From: Carol Reynolds
Sent: 07 March 2019 12:04
To: Anita Gardner
Subject: FW: Nelson Hotel - LU/324/18/PL

Environmental Health: No objection in principal

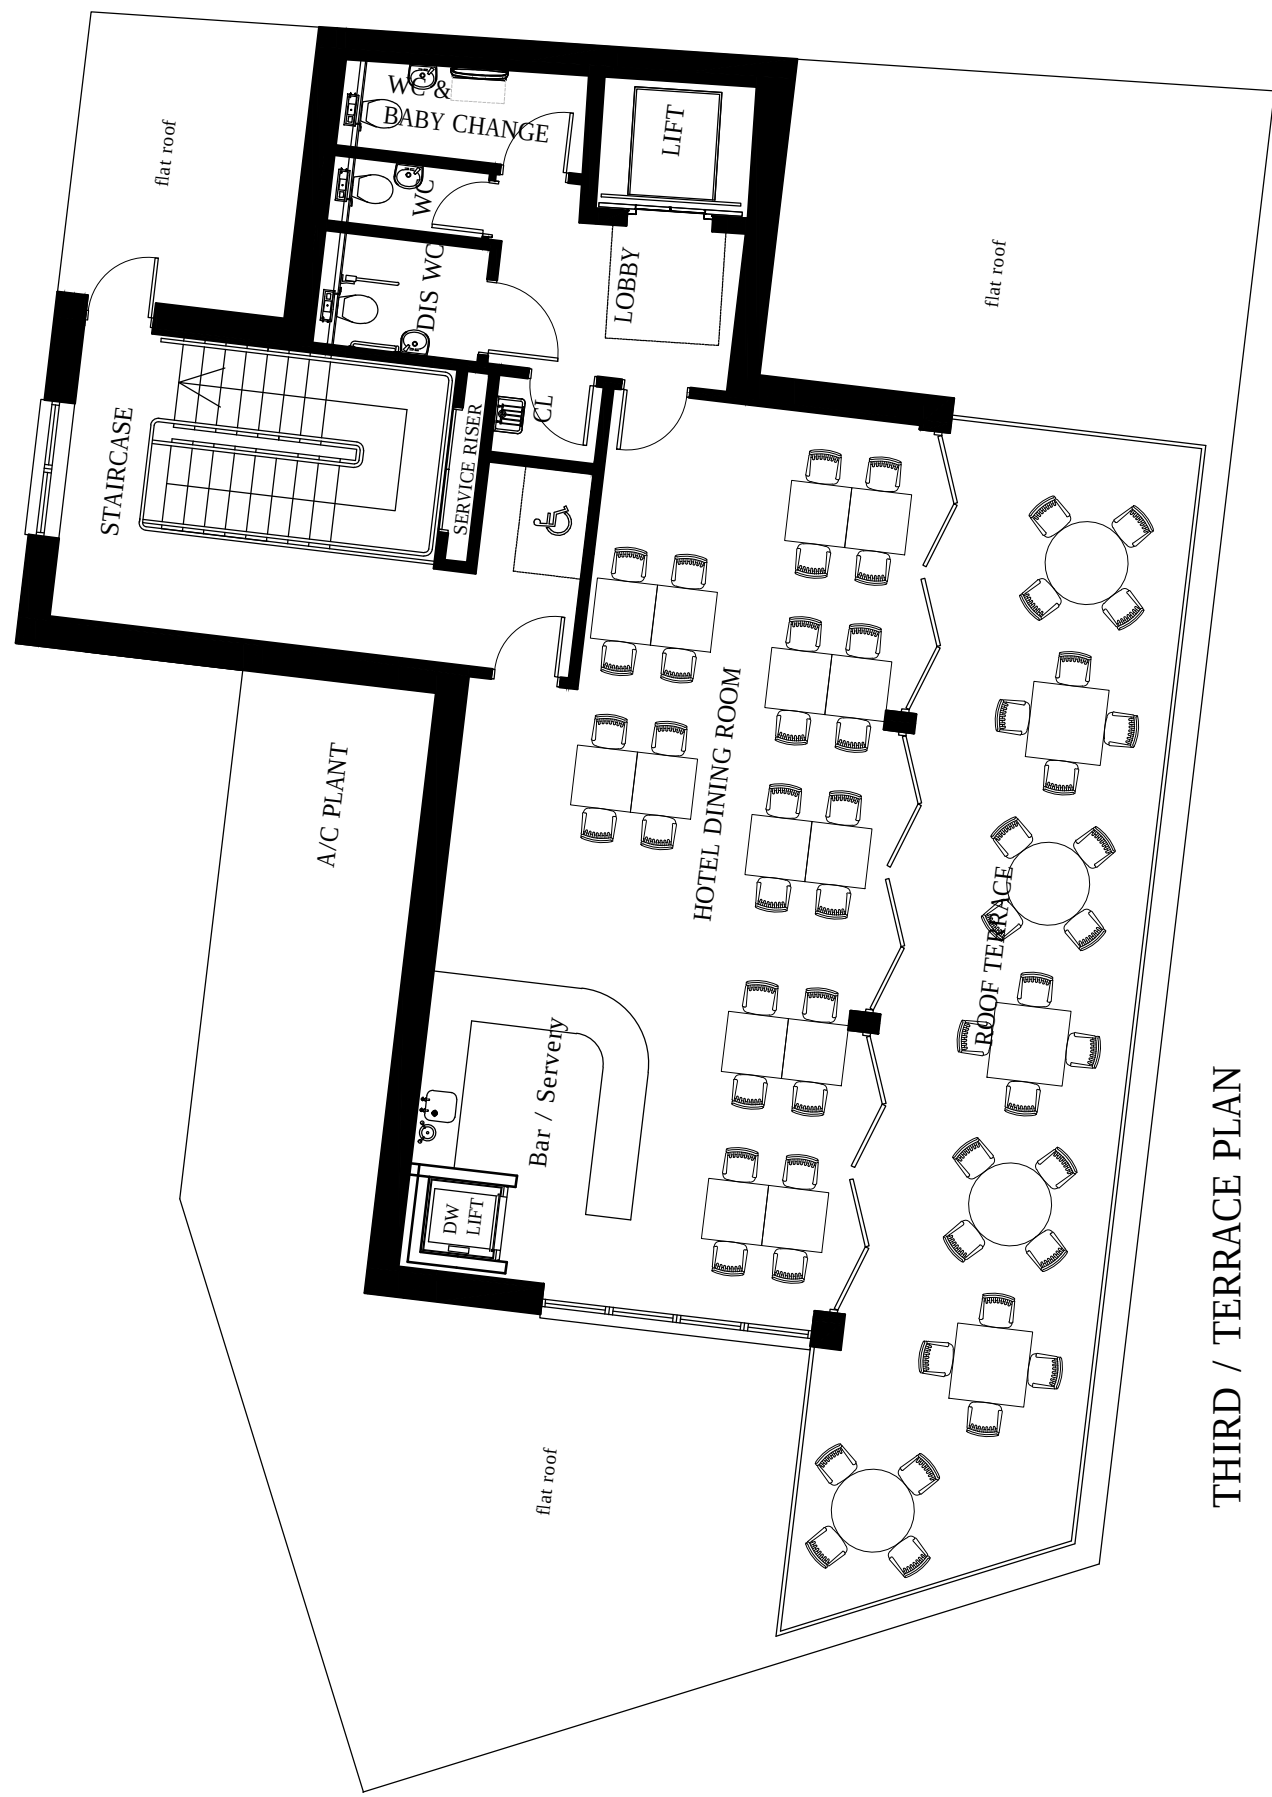
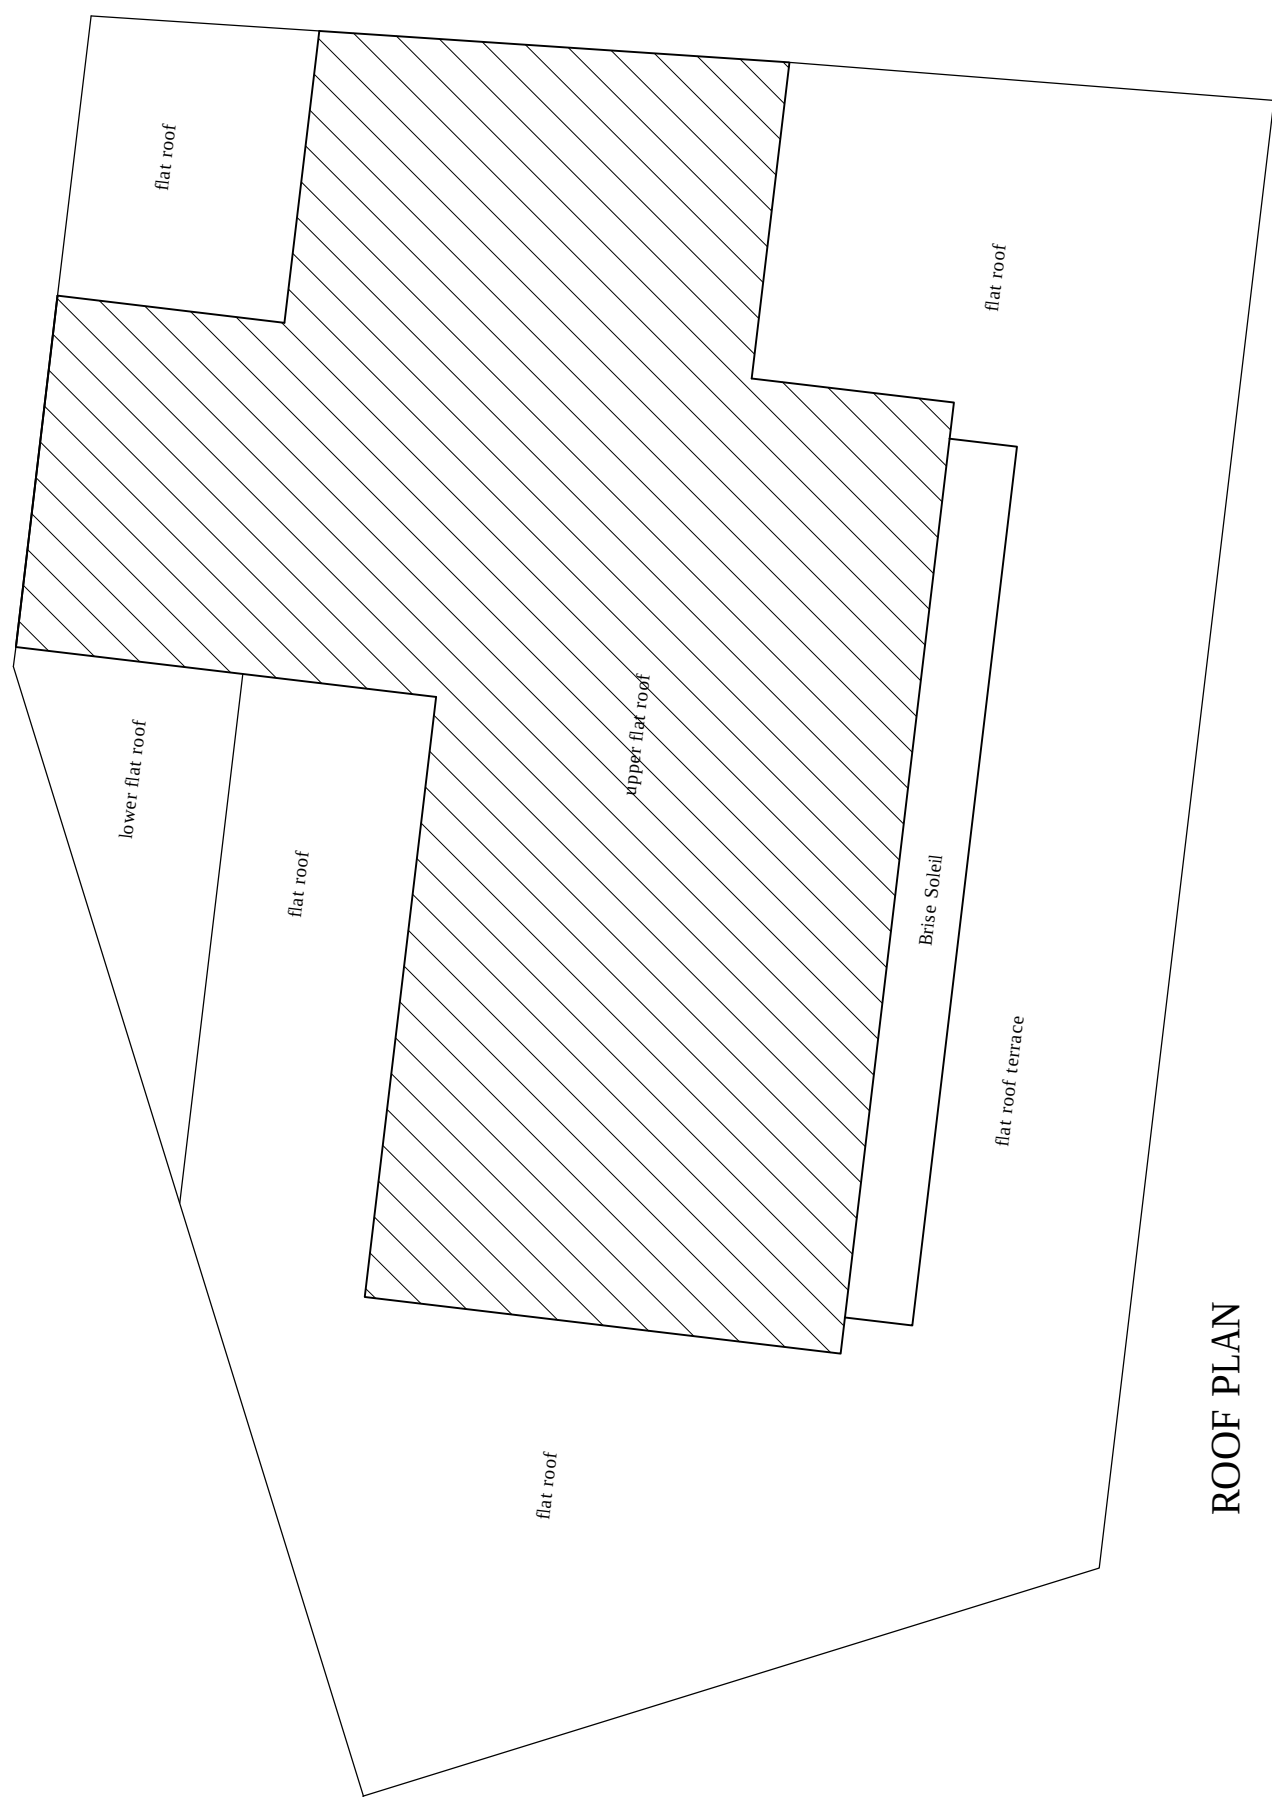
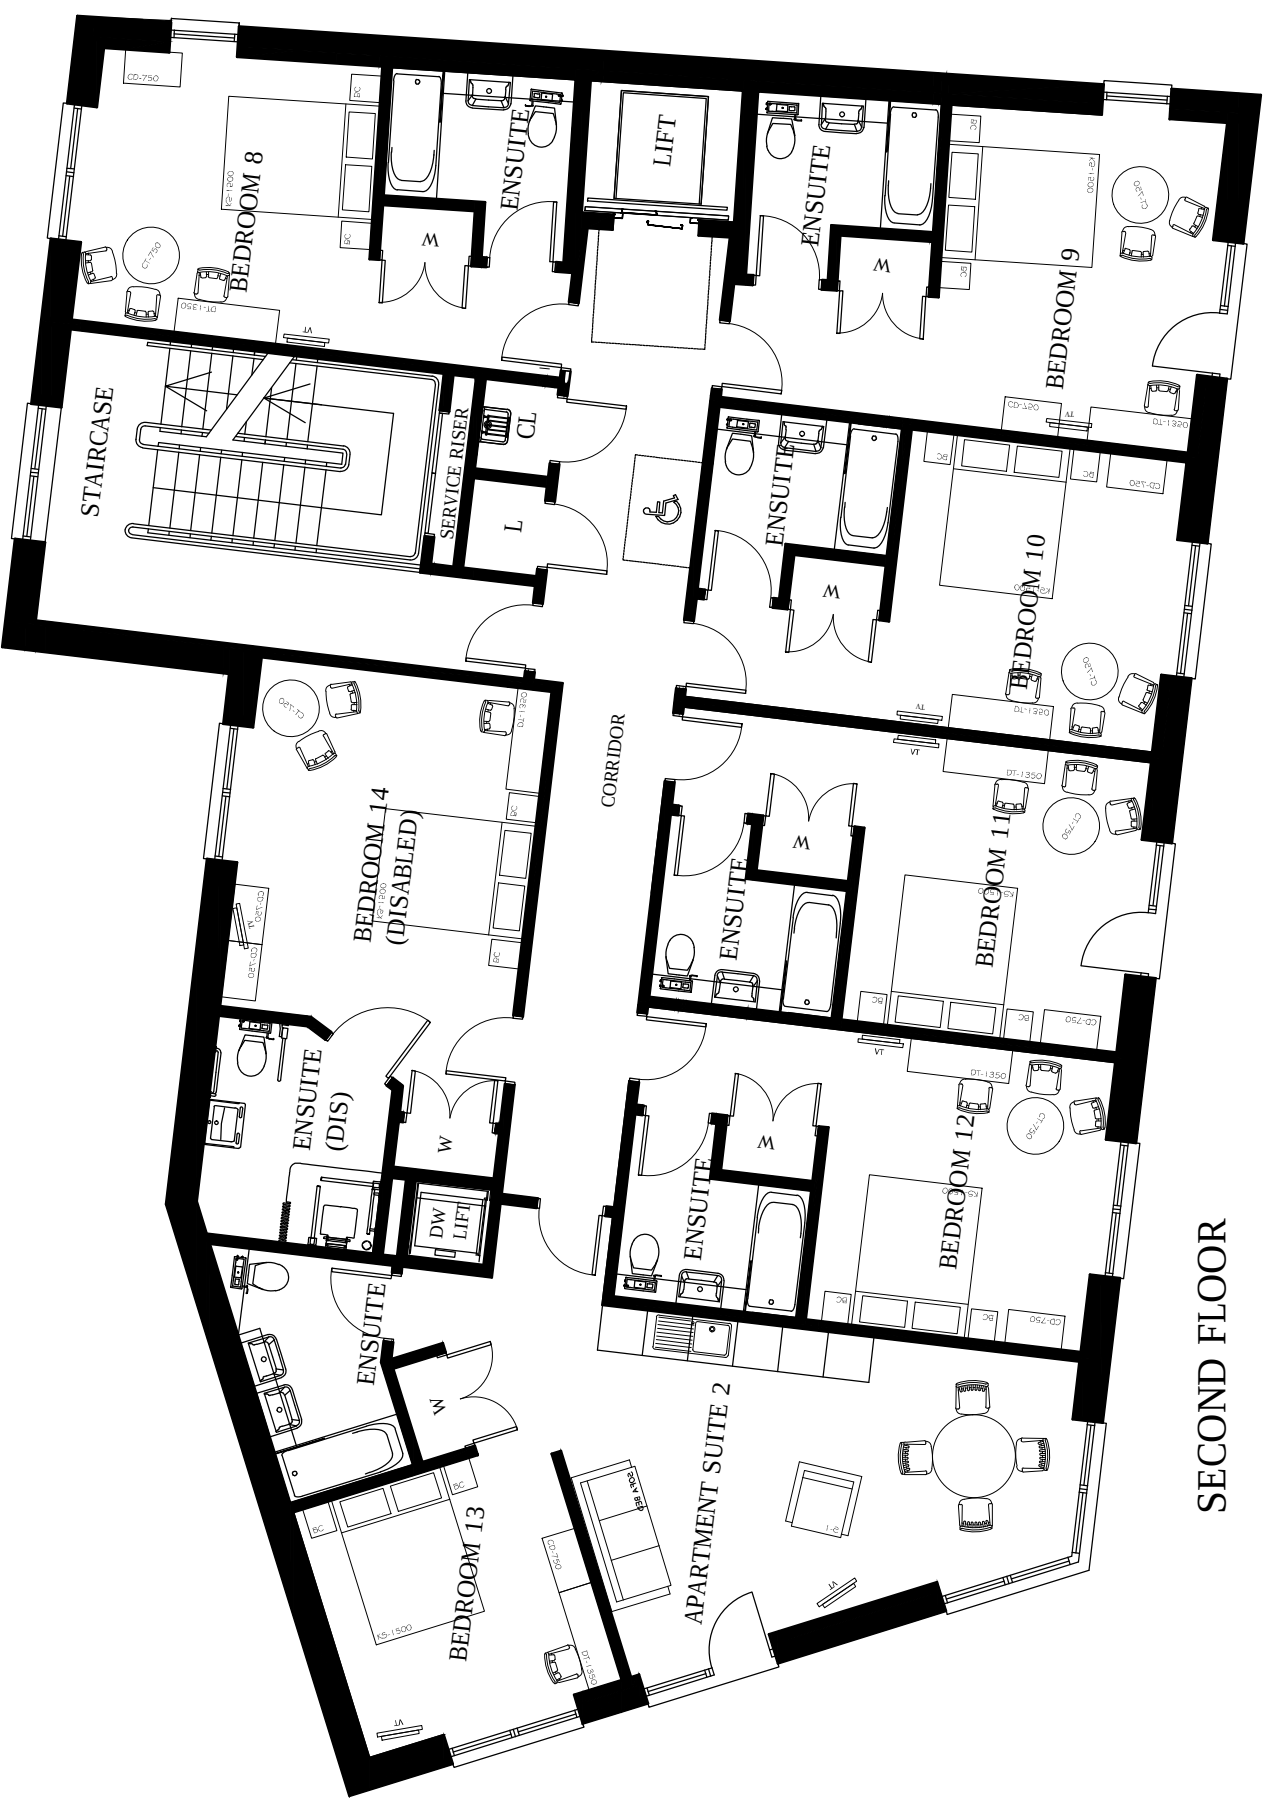
e. Laundry. Please note that ventilation will also be required to the basement laundry facility

a. Please note that a staff/other toilet which enters directly into a kitchen will not be acceptable. The plans as submitted will require modification. In this case it will be necessary to provide suitable clean space for a staff changing.
